From: Peter Robinson [REDACTED]
Sent: 20 May 2018 15:00
To: Mark Jones
Subject: Fw: 84 North Lane. Rustington. Ref. R/13/18/HH

Subject: RE: 84 North Lane. Rustington. Ref. R/13/18/HH

I have now had a chance to discuss the application with the team leader for this area and the view is that there is still issues of concern with the application, as follows, as mentioned previously the key policies are DEV19 and GEN7 of the Arun Local Plan. Therefore, it is still considered that the current proposal comprises major changes and extensions to the building, the original building is lost in the proposed development and as such the proposed scheme is not subservient to the main building. As I mentioned previously the issue of subservient may not be fatal to the proposal on its own. Change is not necessarily bad particularly in an area where there is a mix of dwelling designs and size. The key issue being that other matters such as impact on character of the area and the amenity of adjoining occupiers are satisfactory. However, it is considered that there are potential issues with these two last points.

Proposed Roof Plan

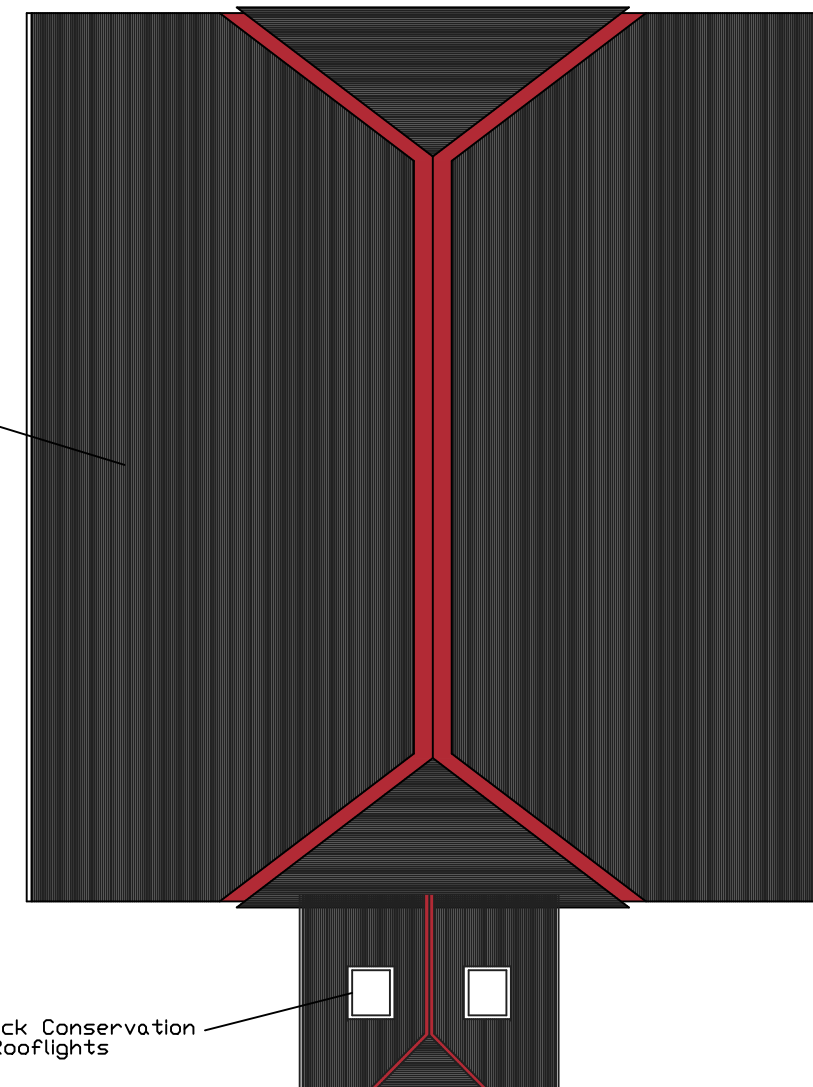
- The proposed scheme still effectively fills the whole width of the plot at two storey height. Indeed given the roof design and height is more akin to a three storey property. It is therefore still felt that the proposed development appears cramped and unduly dominant. As we have mentioned previously, it is considered that the prevailing character does not comprise properties which effectively fill the plot width at least two stories. It is felt that the overriding character is properties with a more space to the side boundaries. Where a greater plot width is present these tend to involve reduction in heights from a two storey to a single storey for example.

Proposed First Floor Plan

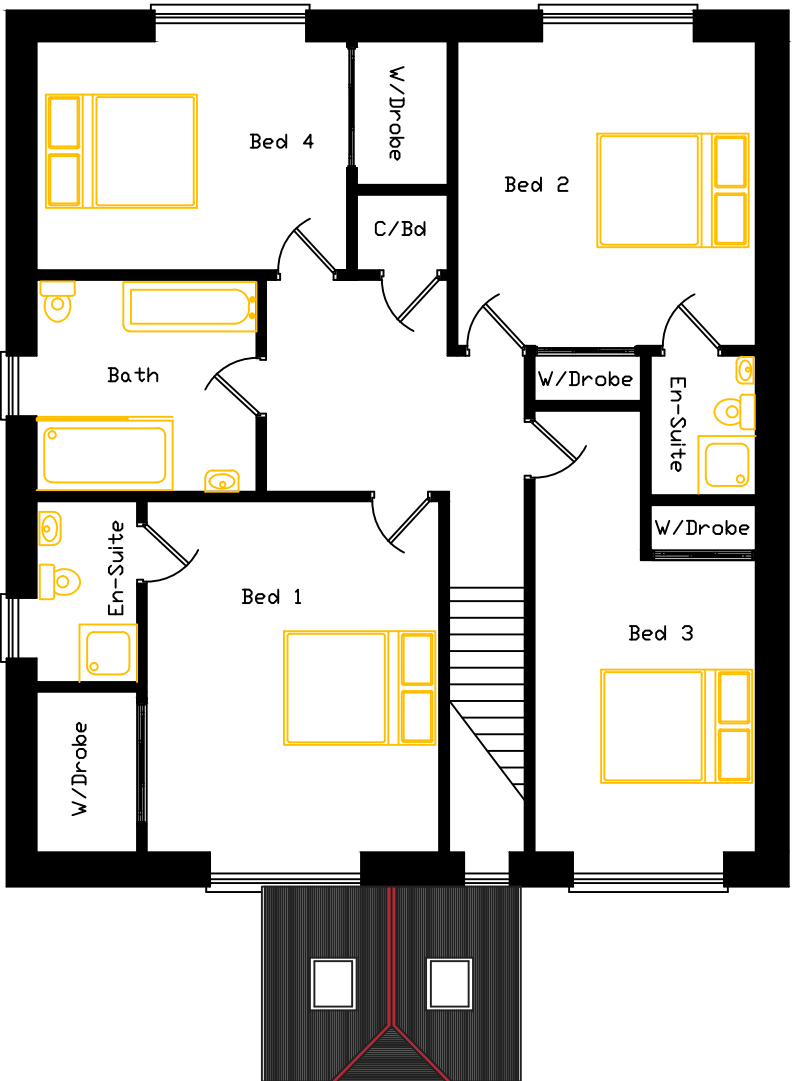
- Whilst the depth has been reduced and the proposal appears to address side windows so as not to lead an unsatisfactory loss of privacy. The rear windows in the rear elevation at first floor level are still considered to have a potential impact on the adjoining property to the south. This impact is less to the northern boundary due to the position of the neighbouring dwelling and separation distance.
